Planning Application Ref: BN/128/19/OUT

Location: Land Adjacent to Highfield House, Yapton Road, Barnham, PO22 0AZ

Description of works: Application for outline planning permission for development of 70 bed Care Home and 14 Assisted Living bungalows with associated car parking, landscaping and access - Departure from the Development Plan

SITE PLAN  
1/250

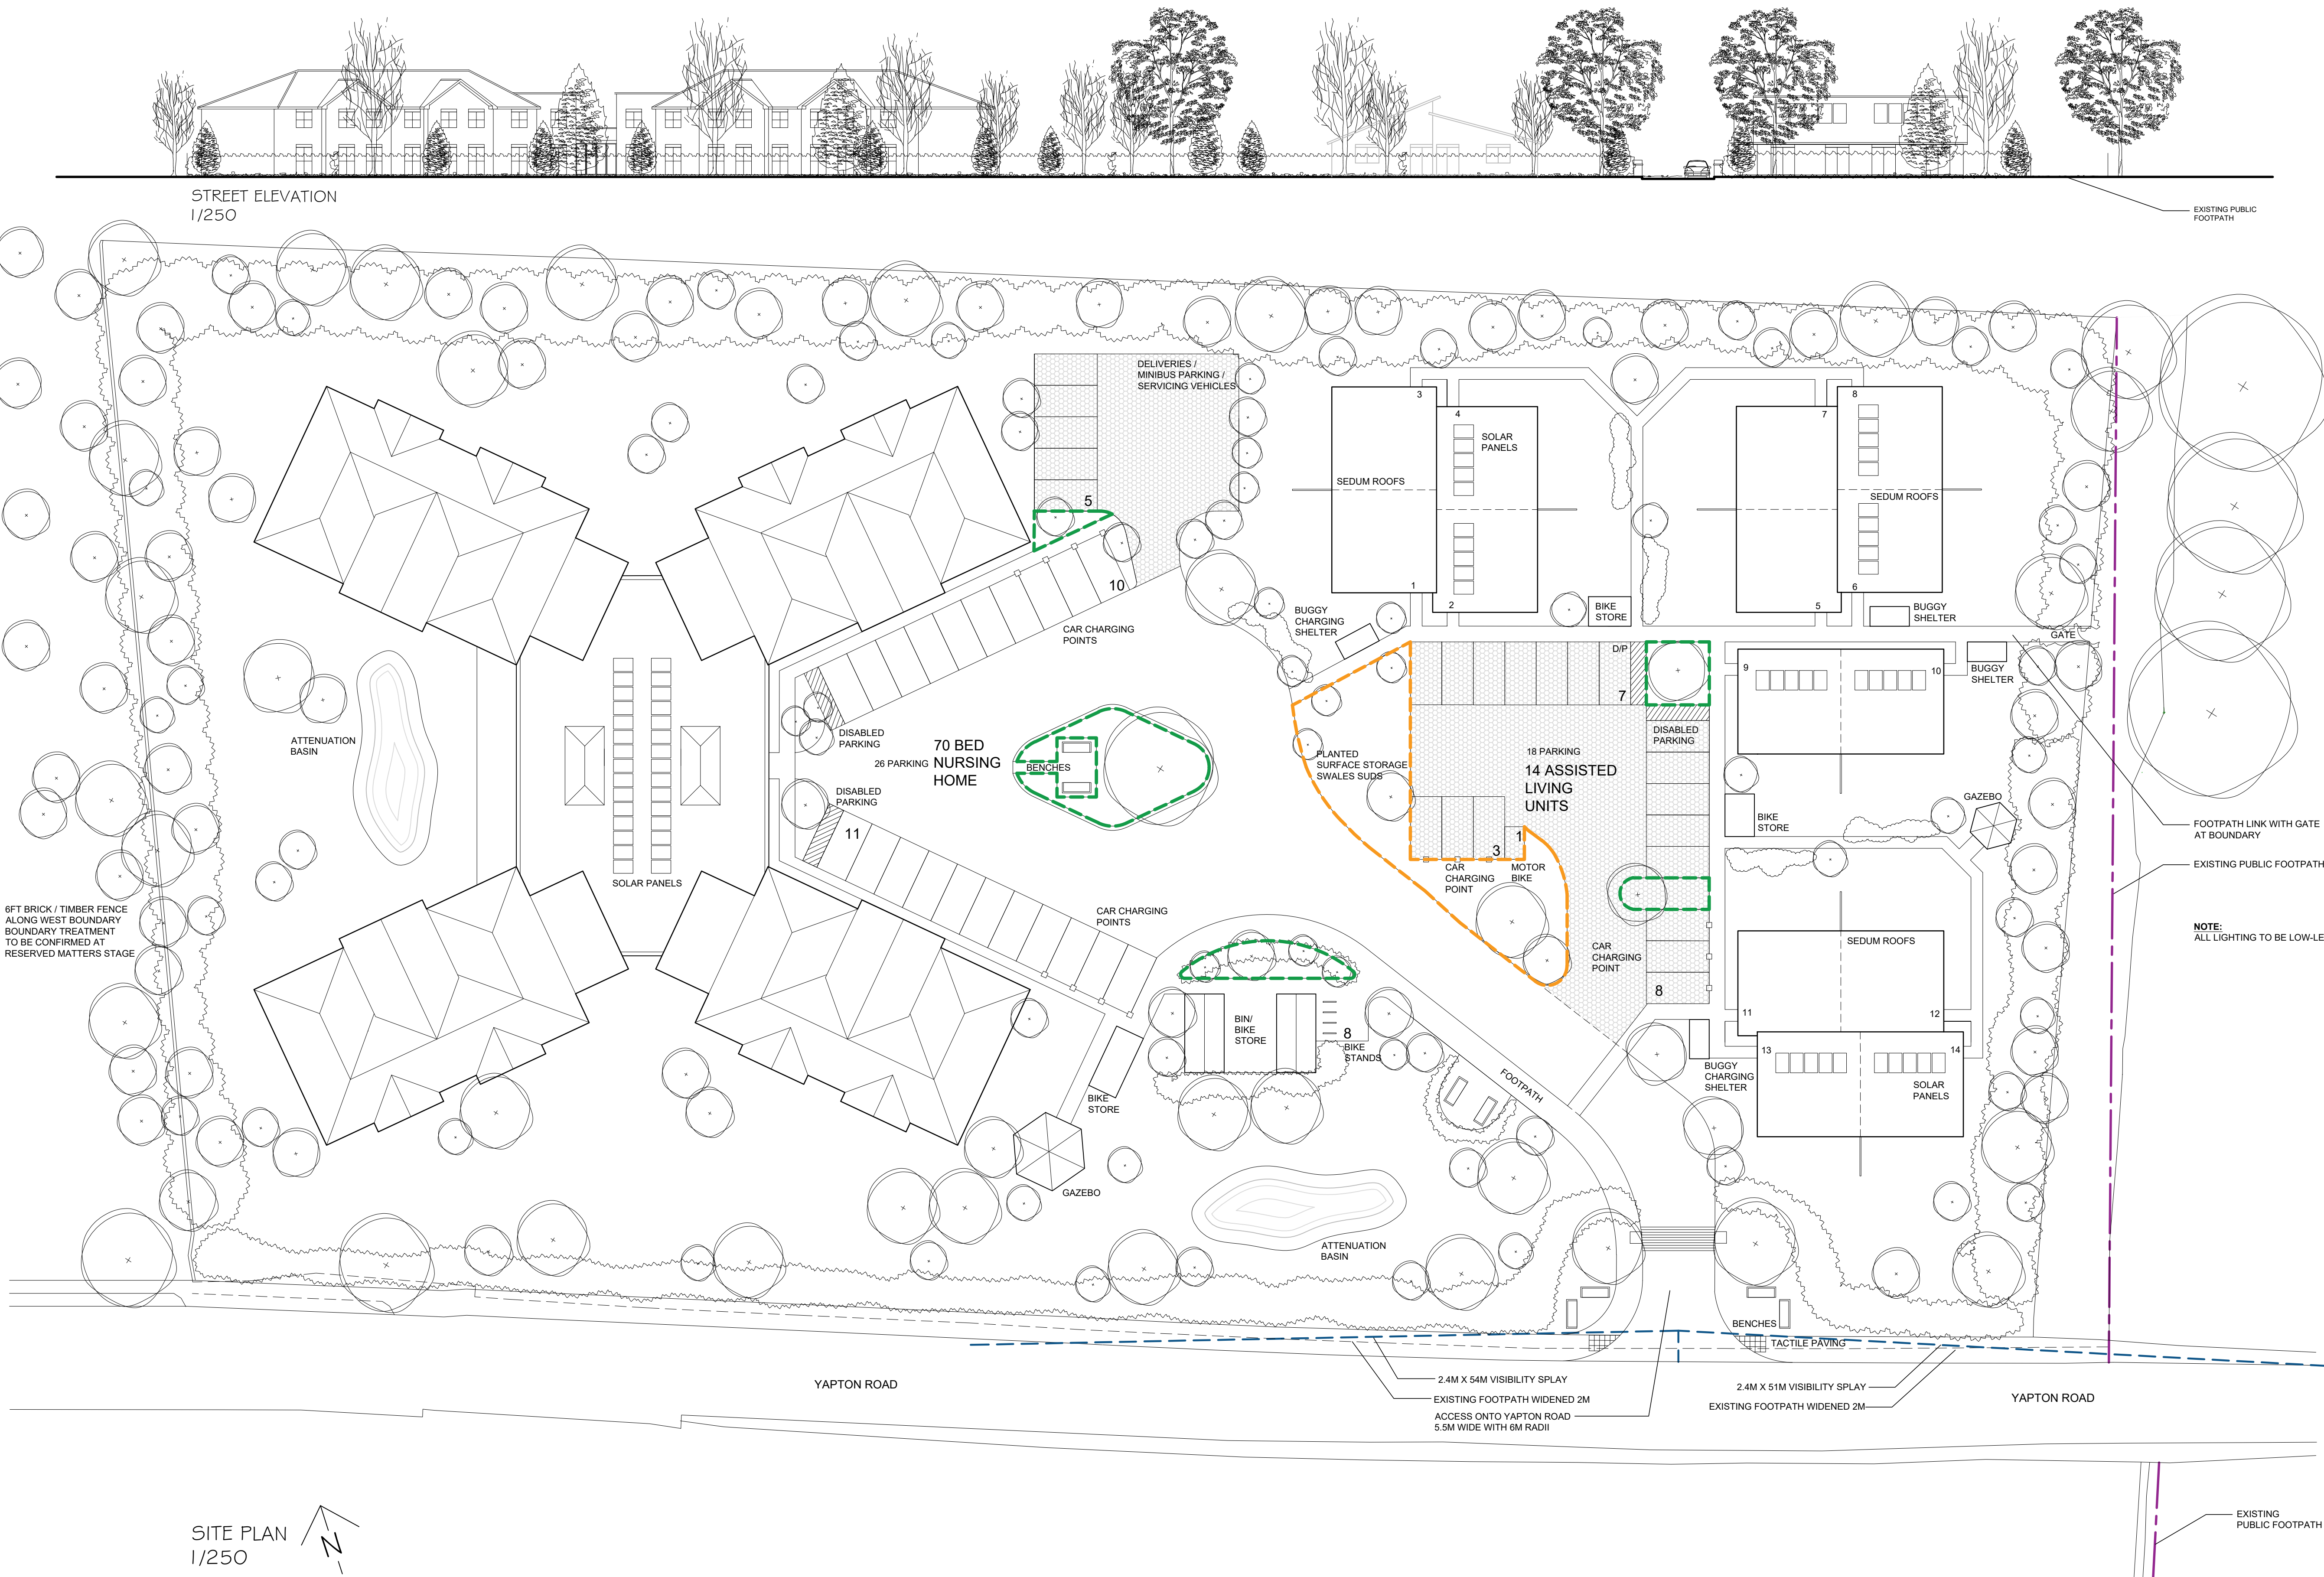
- I see no obvious problem with the proposed location of the main access to site, although inevitably a substantial section of the boundary hedge-line will need to be removed to achieve adequate vehicle sightlines. That can and should be mitigated with an ambitious, detailed landscape plan that enhances the existing hedgerow coverage and so compensates in some way for the loss of connectivity. The arboricultural report promotes an 'excellent opportunity' for tree and shrub planting to provide significant net gains in ecological terms and visual interest to soften the impact of development (sect. 2.4, para.6). I would expect an ambitious scheme to come forward for our approval and which should then be secured by condition. I defer to our Principal Landscape & Project Officer, who I trust will have further opportunity to comment on the suitability of their proposals, once the necessary detail requested has been provided.

TREE PROTECTION PLAN

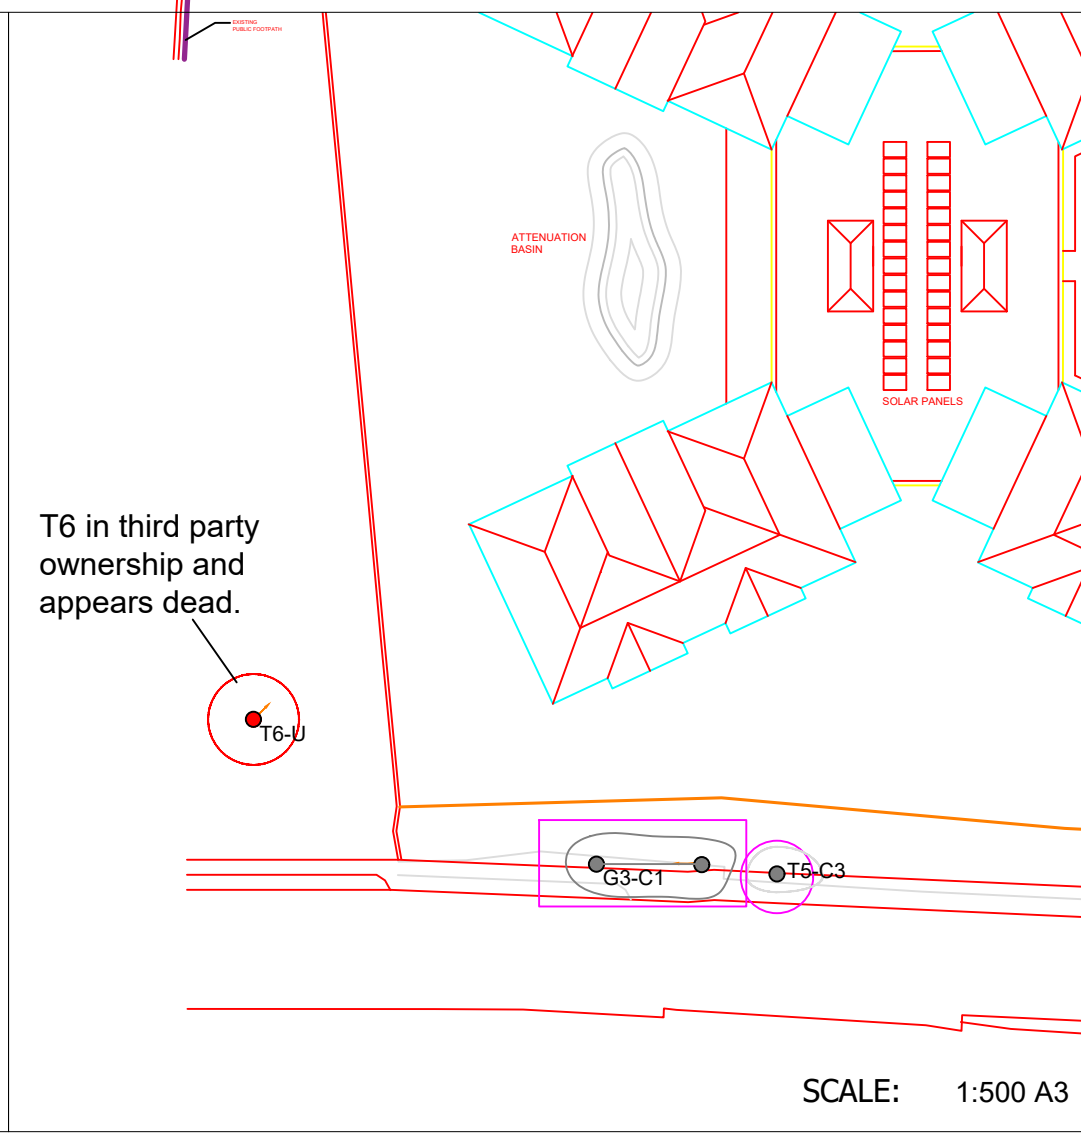
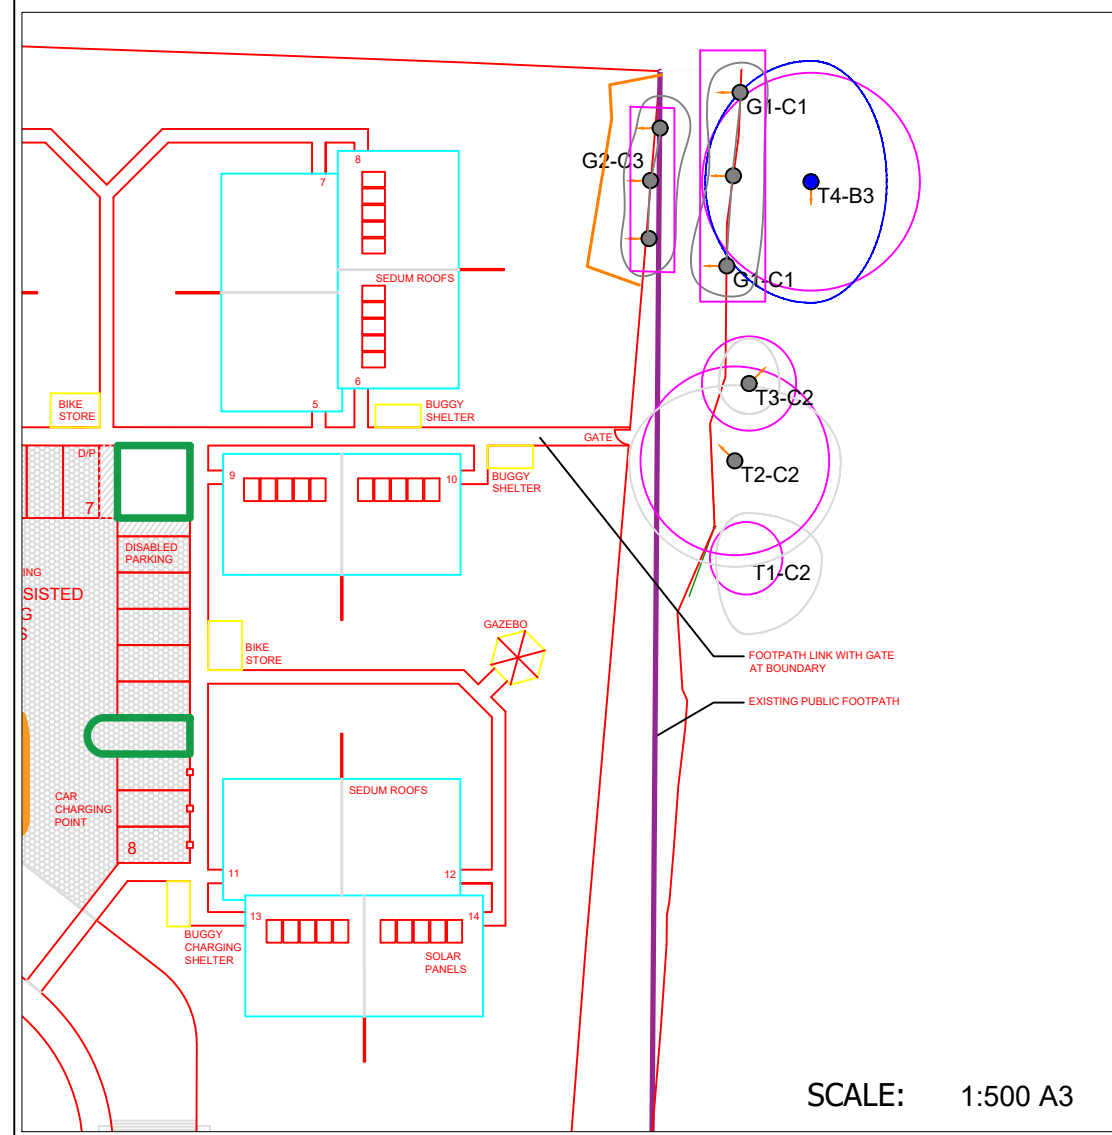
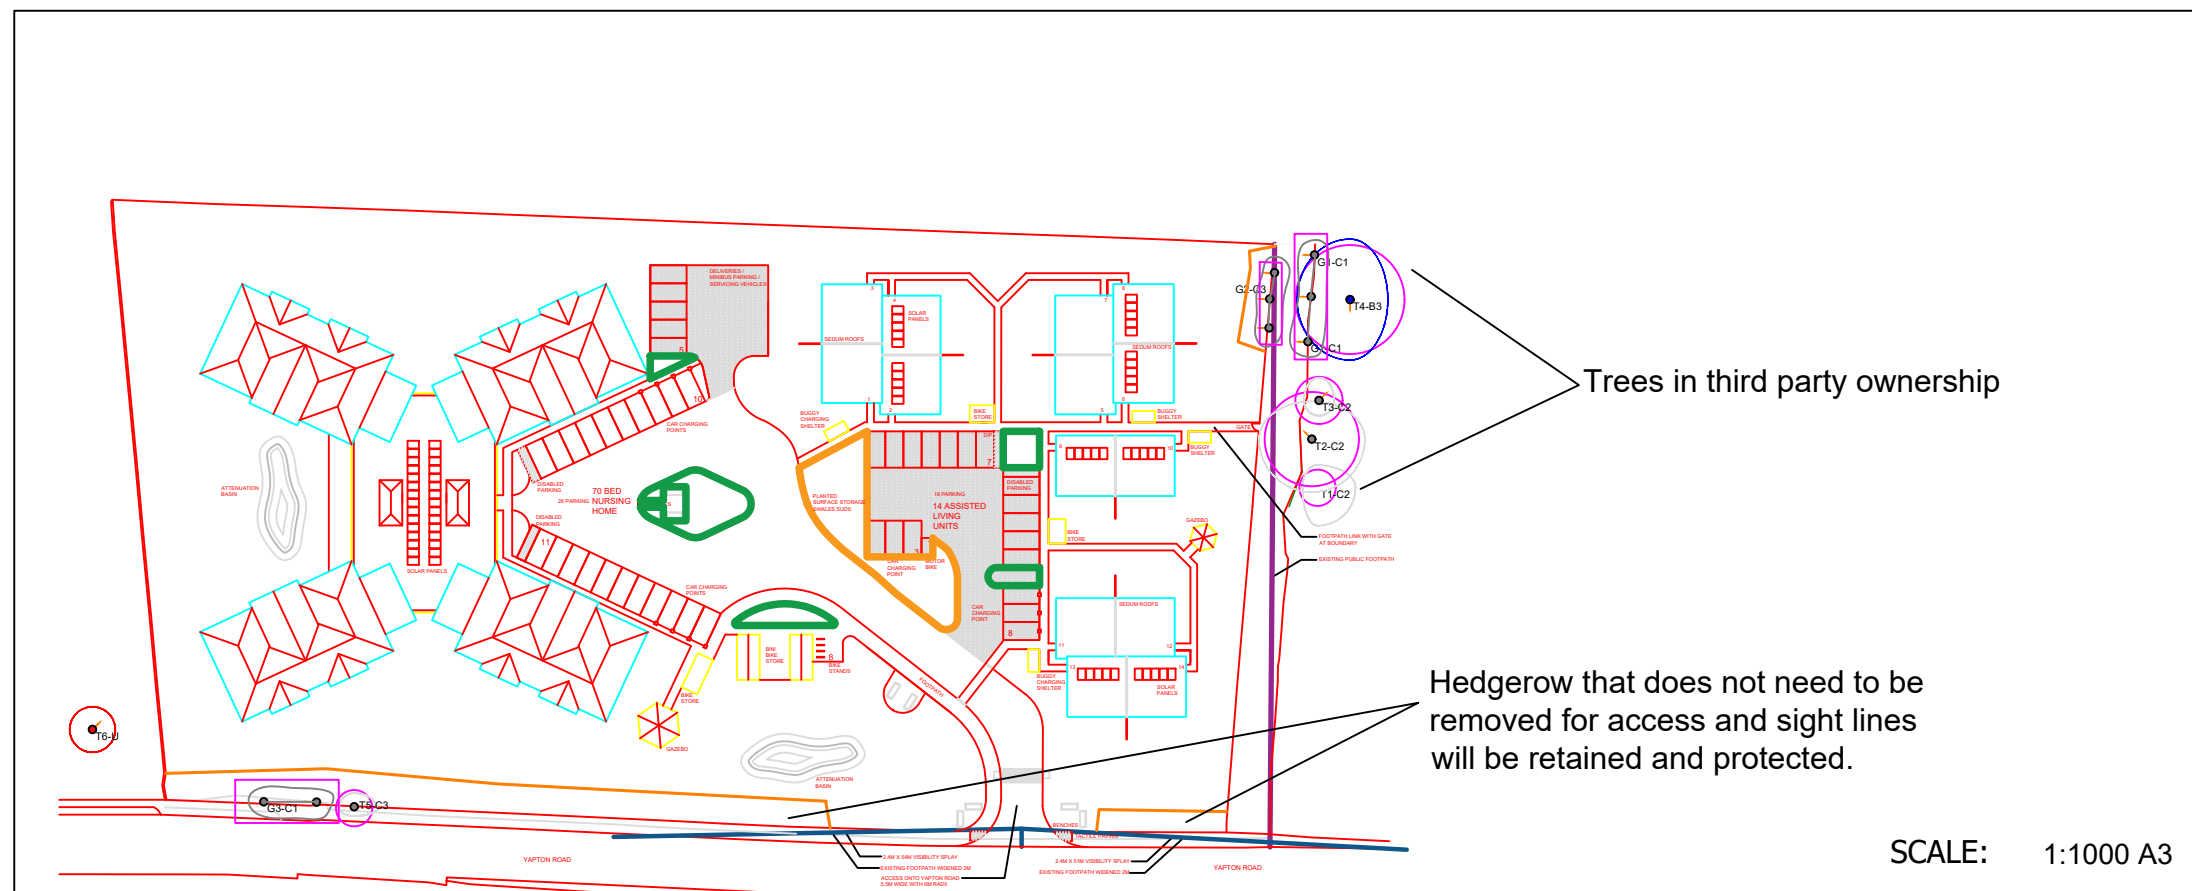
- In respect of Tree Protection Measures:
 - Were this development to proceed, it would be both prolonged and involve multiple contract elements and staged introduction of new personnel through to completion. As such, I consider it necessary and proportionate to employ the highest standard of protective fencing, which is both fixed securely and can be highly effective. This would apply to all locations where fencing is proposed, as per the aforementioned Tree Protection Plan.

- These amendments will need to be incorporated into the Arboricultural Report and all otherwise generic references to protective fencing or lesser specifications removed, so as to provide absolute clarity.

- In respect of fencing specification for inclusion in the report, I suggest the following wording is used: *'The fence will consist of "Heras" type panels or similar braced at appropriate intervals and secured to keep in place'. Those panels are to be mounted on a rigid scaffold framework supported by back-stays and vertical poles at appropriate intervals and driven a minimum 600mm into the ground – so as to be 'fit for purpose' (as per Figure 2, BS5837:2012, Default specification for protective barrier).'*
